Consultation Response from KC, Conservation and Design		
2021/93688 75, New North Road, Edgerton, Huddersfield, HD1 5ND		
Listed Building Consent for internal and external alterations, installation of rear disabled access ramp (within a Conservation Area)		
Date Responded: 2.2.22	Responding Officer: Sue Brooks	Responding Ref: HUD 27/1009
Following previous comments and subsequent amendments and justification, our updated response is below: Externally, the proposed changes are quite minimal and are generally acceptable, subject to the comments below: • New aluminium downpipes should have a round section, while gutters should have an ogee section. • Widening the rear doorway - the existing stone jambs will be re-used. If a new lintol is required this should be in stone and should match the existing in terms of stone type, tooling, bedding and colour. This can be included as a condition. A timber panelled door is proposed and is acceptable. • The proposed bin store and cycle store have been relocated to the side of the garden against the boundary wall, with 1m high metal fencing around the stores. This reduces the impact on the listed building and is acceptable. Details should be subm

2 Proposed Ground Floor Plan
1 : 100

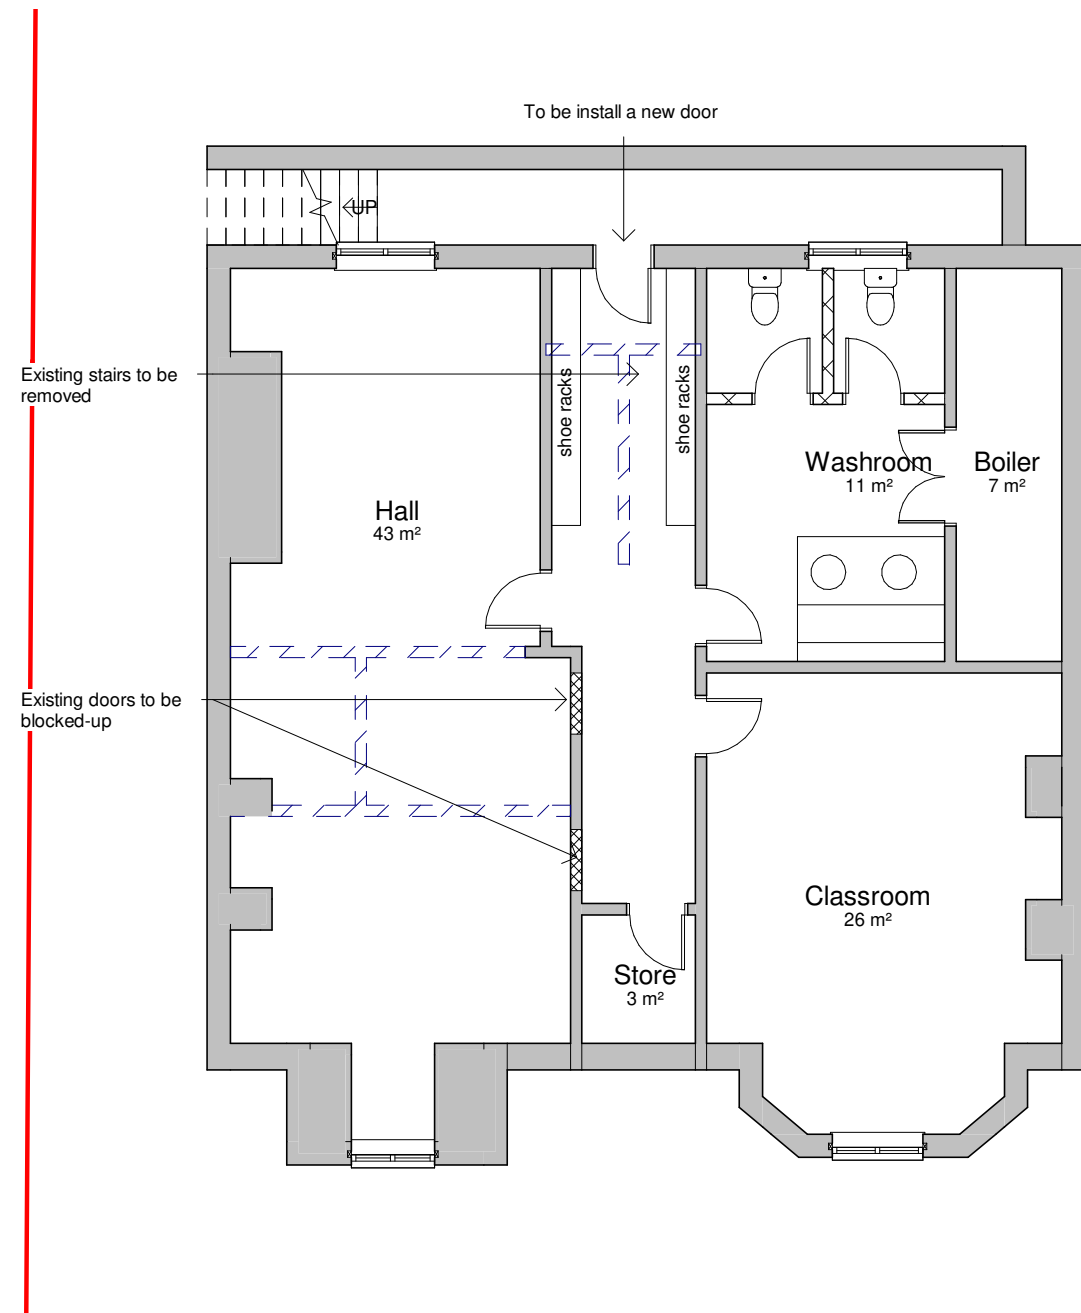
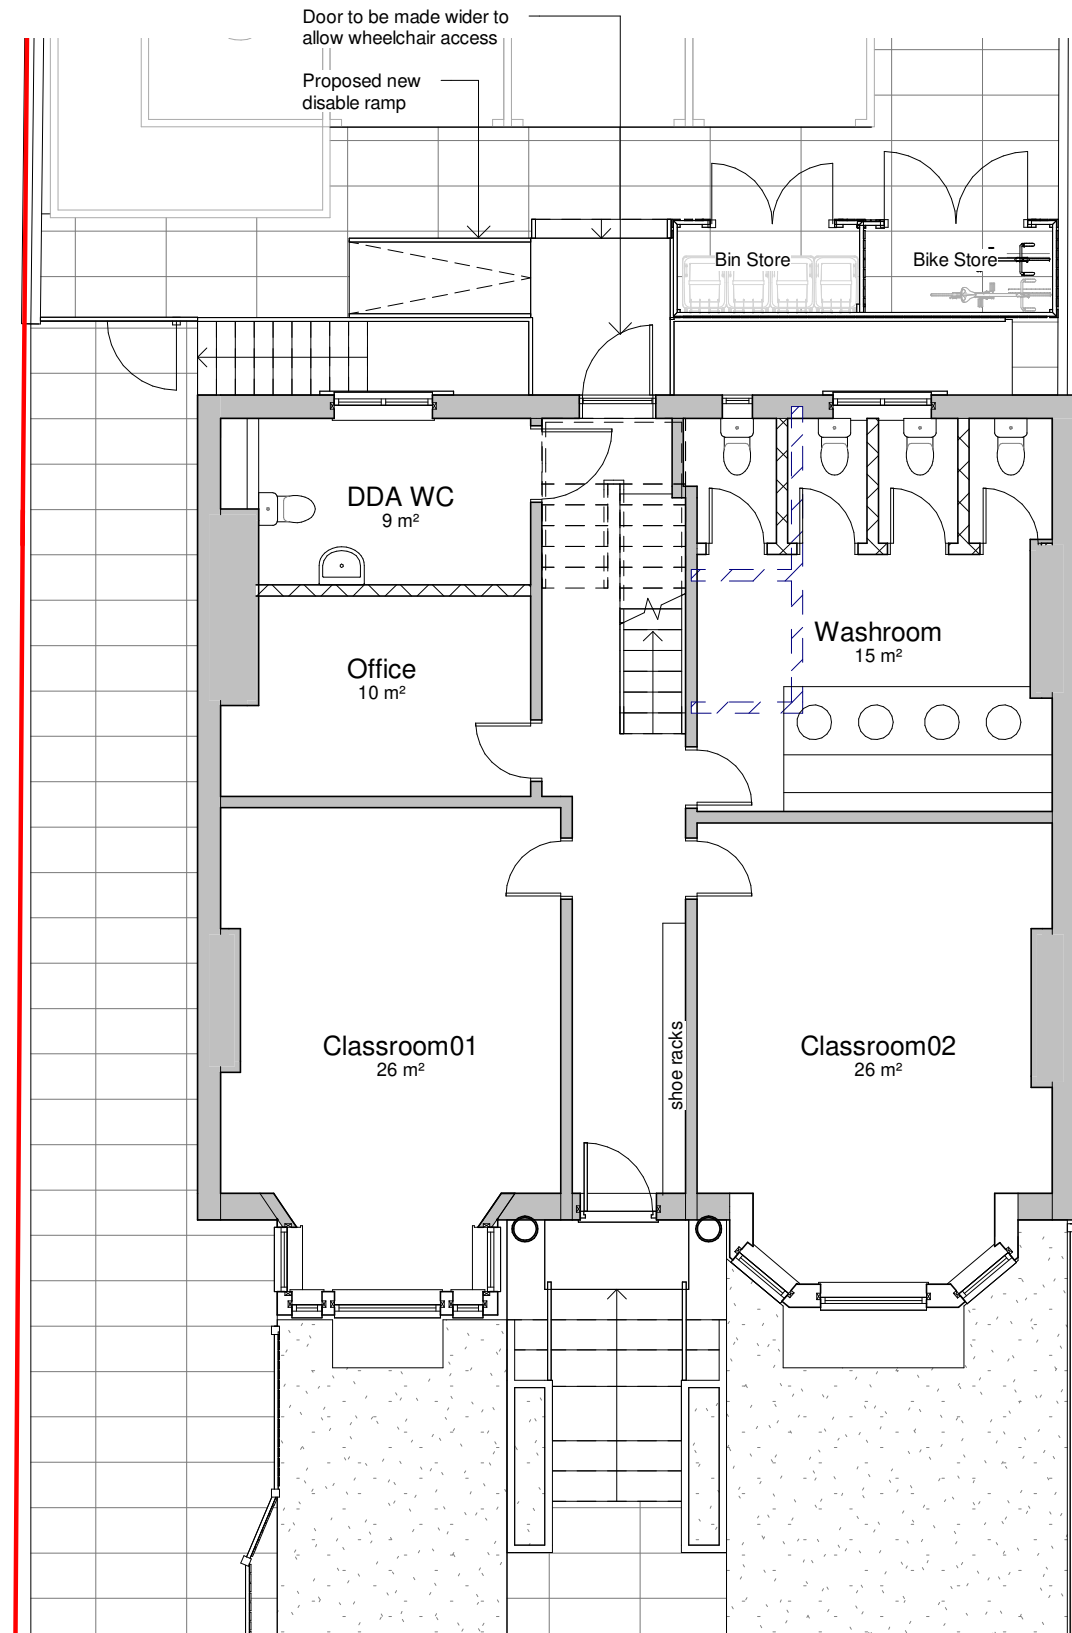
The application has been amended to reduce the extent of further internal demolition, with the sufficient retention of internal walls to the rear for the historic floorplan to be understood. The loss of the central front room in its entirety is still proposed, and we would recommend that the beams supporting the original walls are boxed in below the ceiling height to retain an indication of the original layout. It is unclear why a small office needs to be formed within the rear room and instead we would suggest that the existing room is used for this function.
